CITY OF ALBUQUERQUE

Re: 8950 Oakland NE Grading and Drainage Plan
Engineer's Stamp dated 10-27-08 (C20/D065)

Based upon the information provided in your submittal received 10-27-08, the above referenced plan is approved for Building Permit.

8950 OAKLAND NE
RESIDENTIAL G & D
PLAN REVISION PREPARED BY:
BERNARD R. FREEMAN, PE

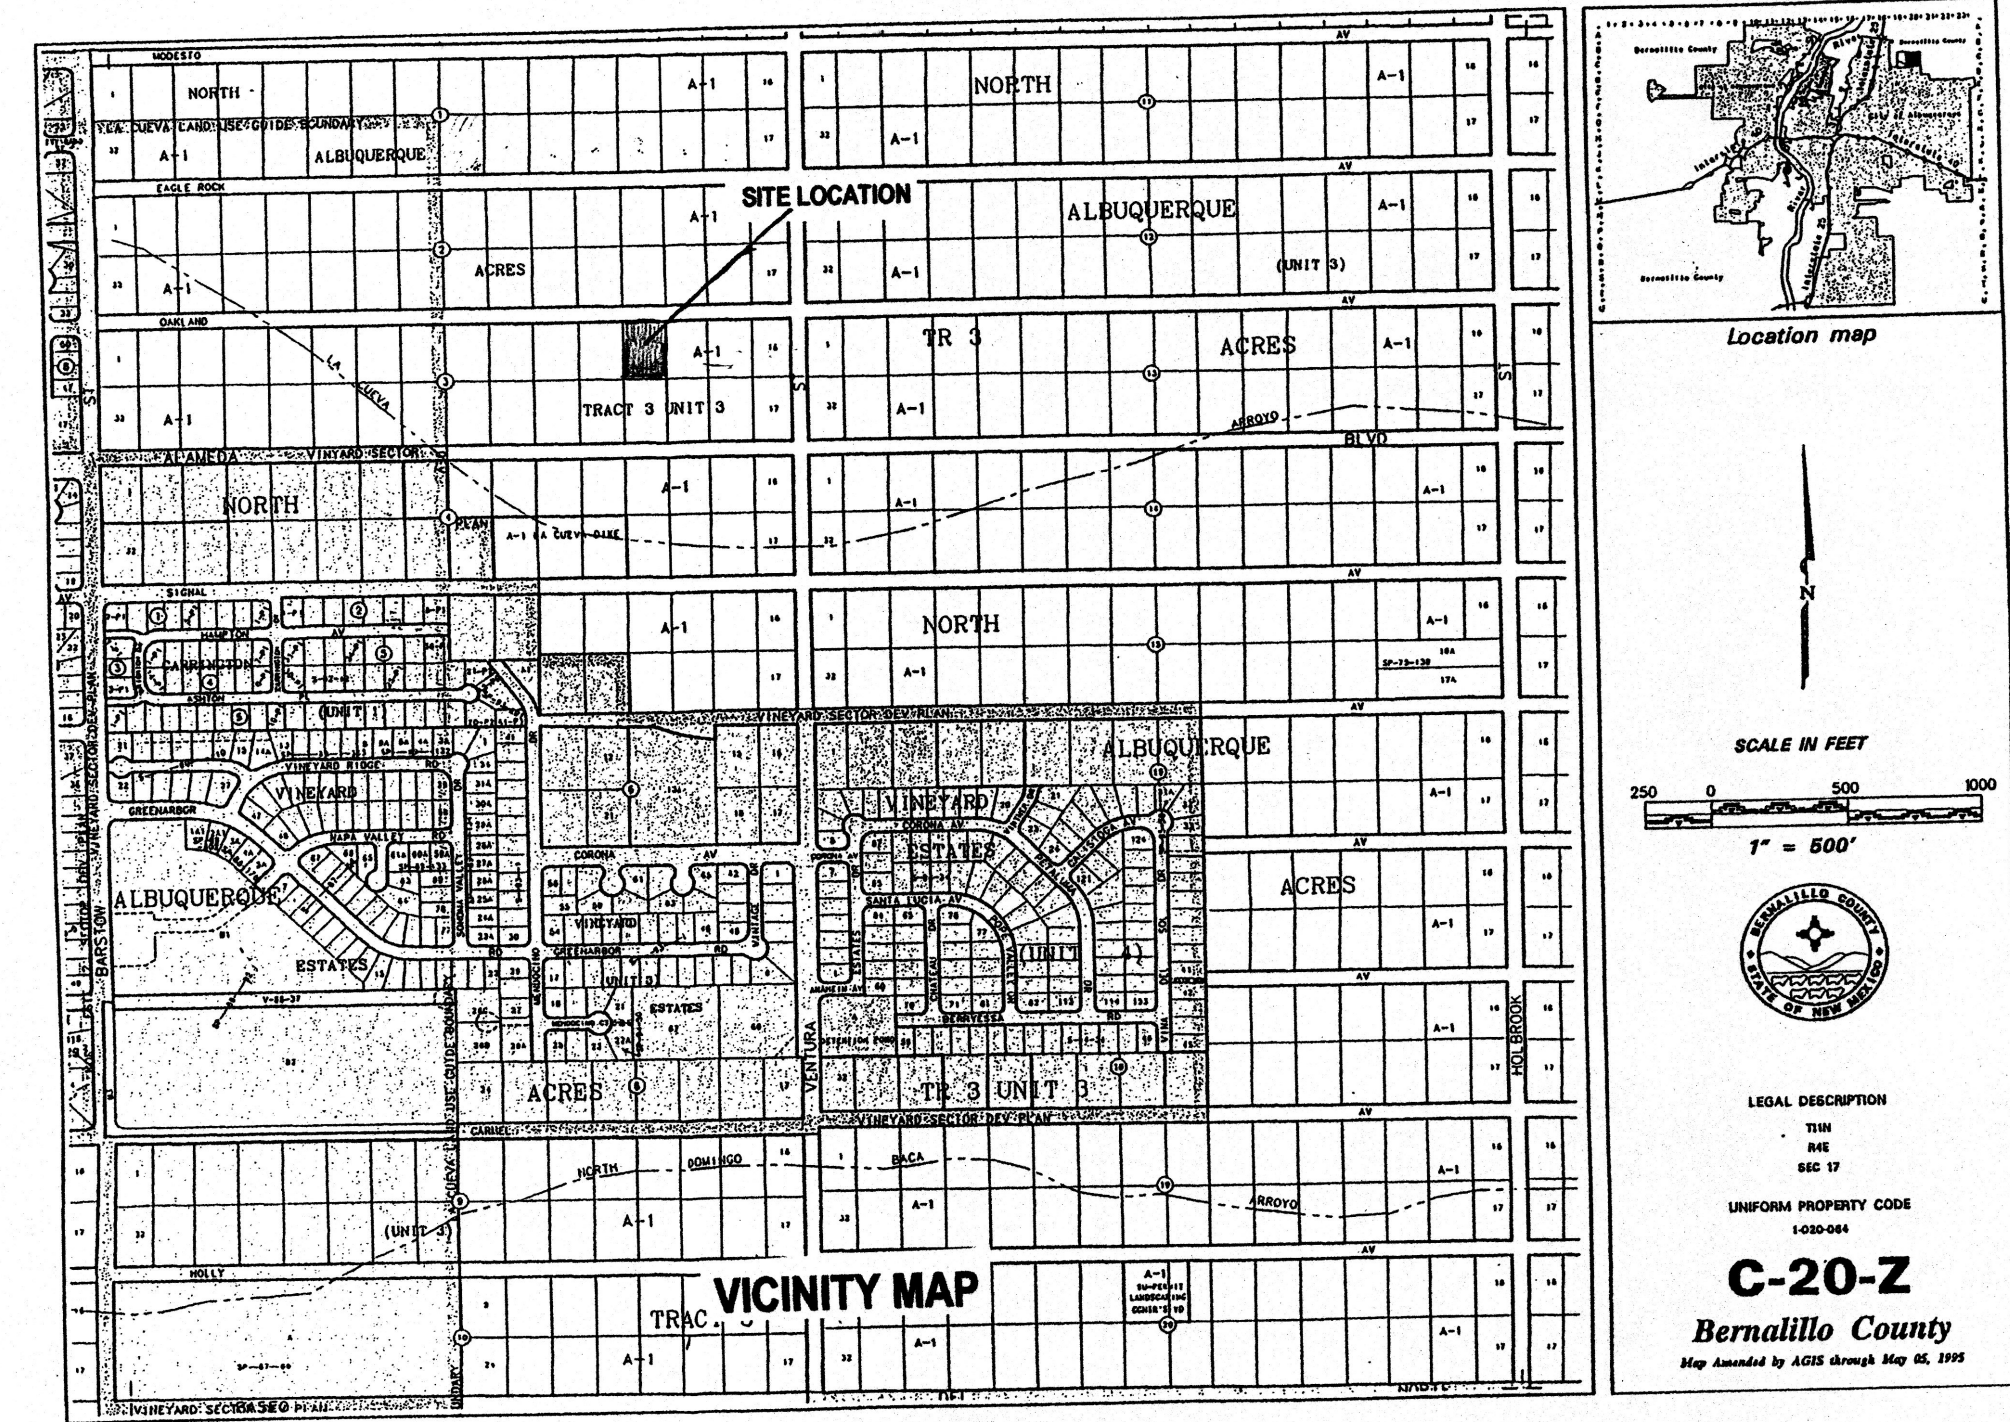
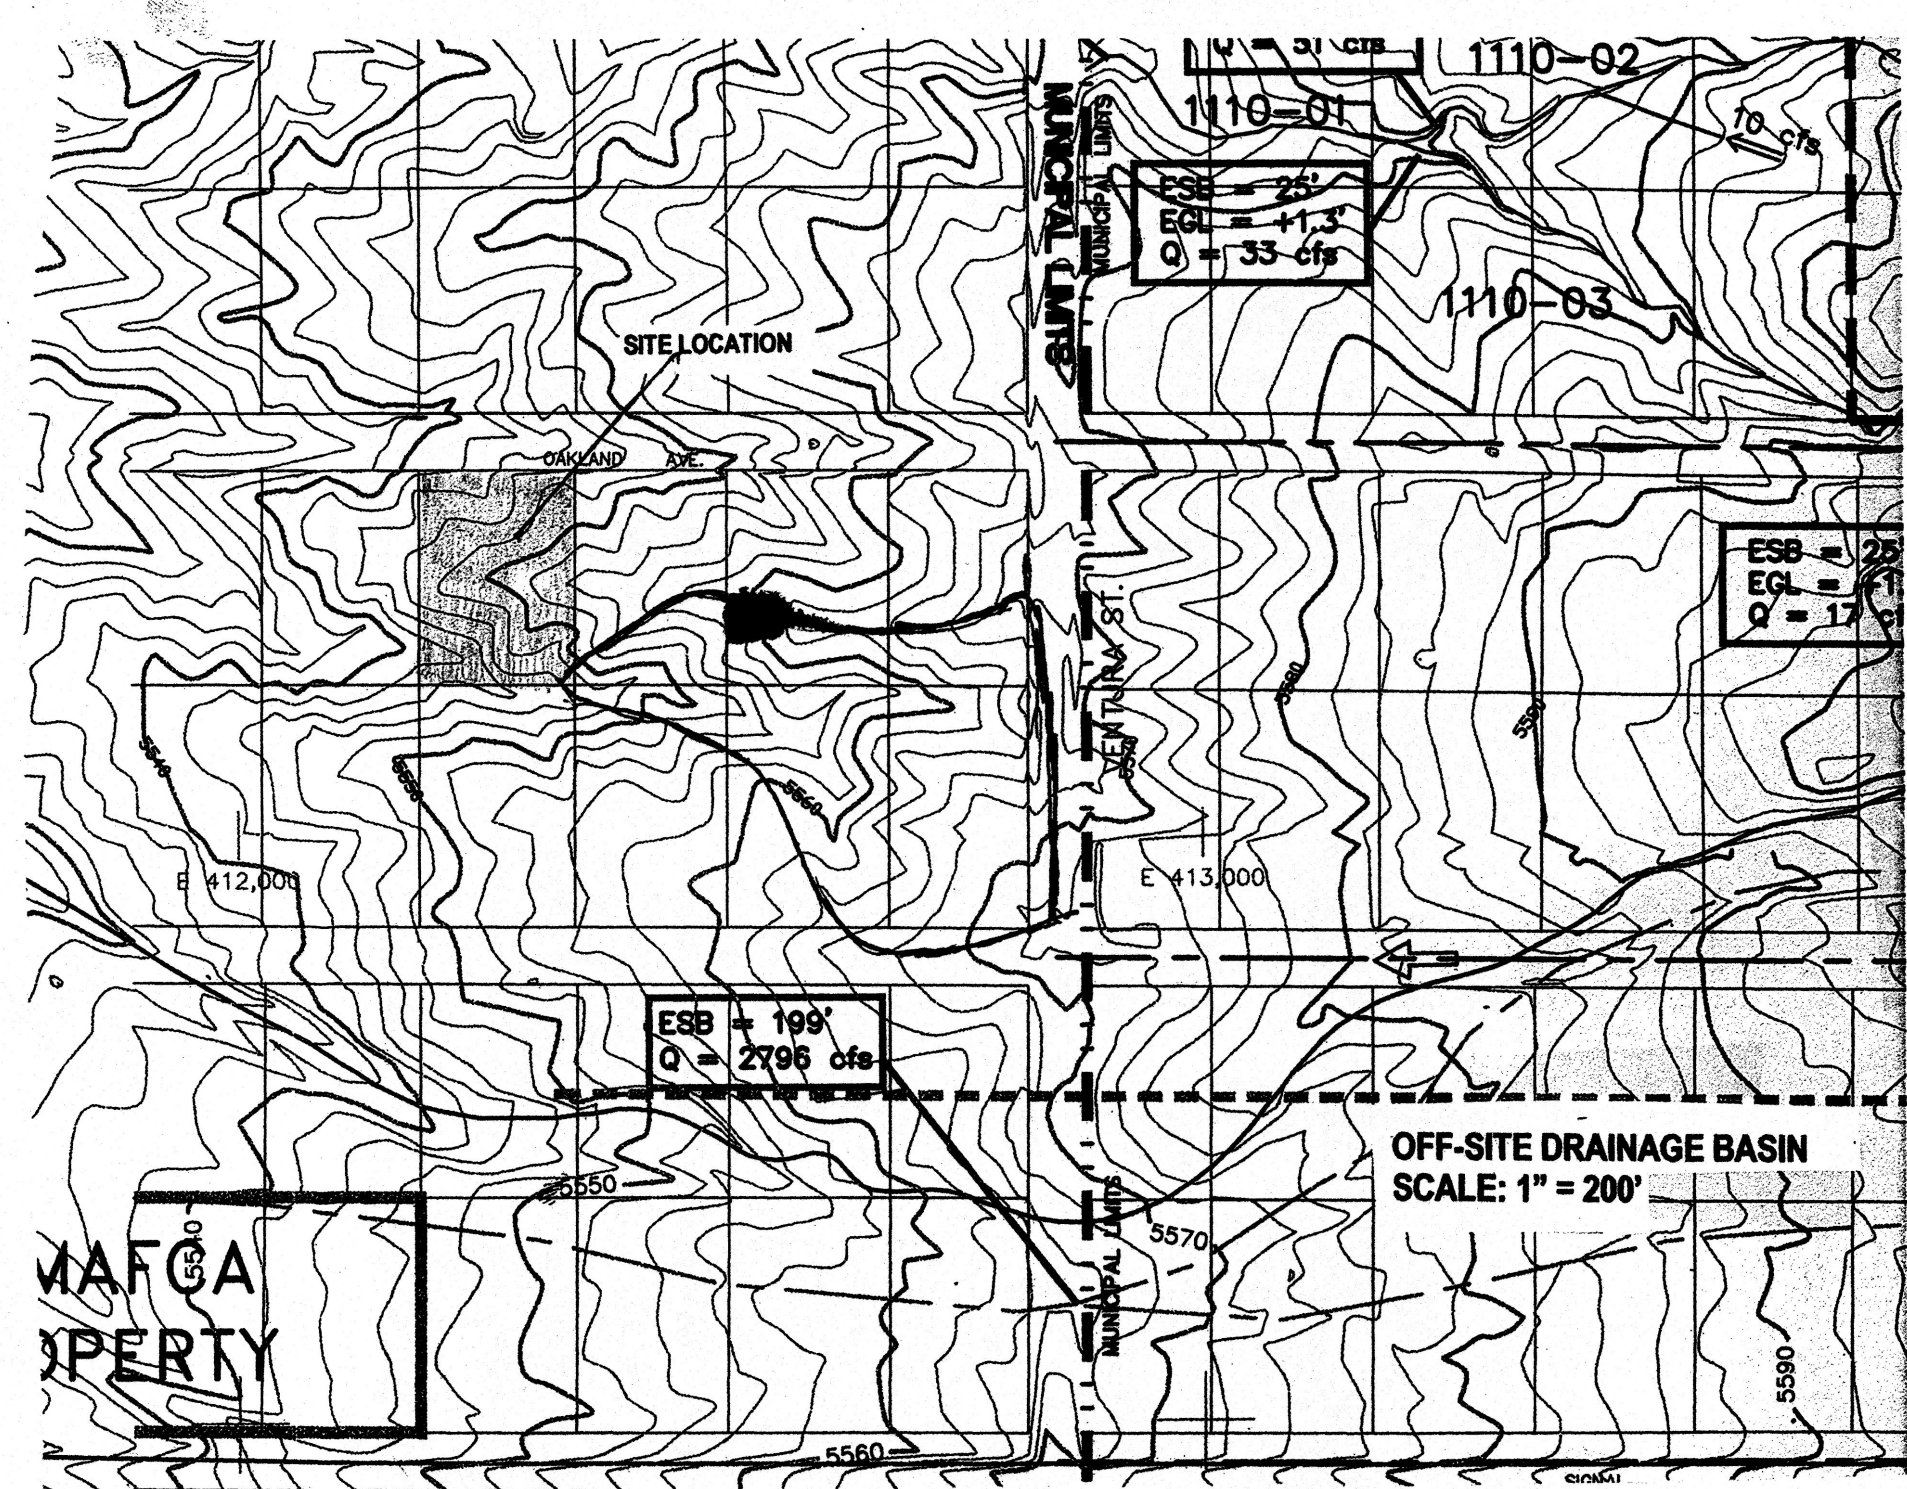
PO Box 1293
Albuquerque
The grade along the south/southwest of the pad is approximately 3:1. Slopes steeper than 3:1 should have an engineered specified method of erosion control. In addition, arroyos tend to migrate laterally so you might get some cut in this area. You may want to consider some form of hard-lined protection or a wall.
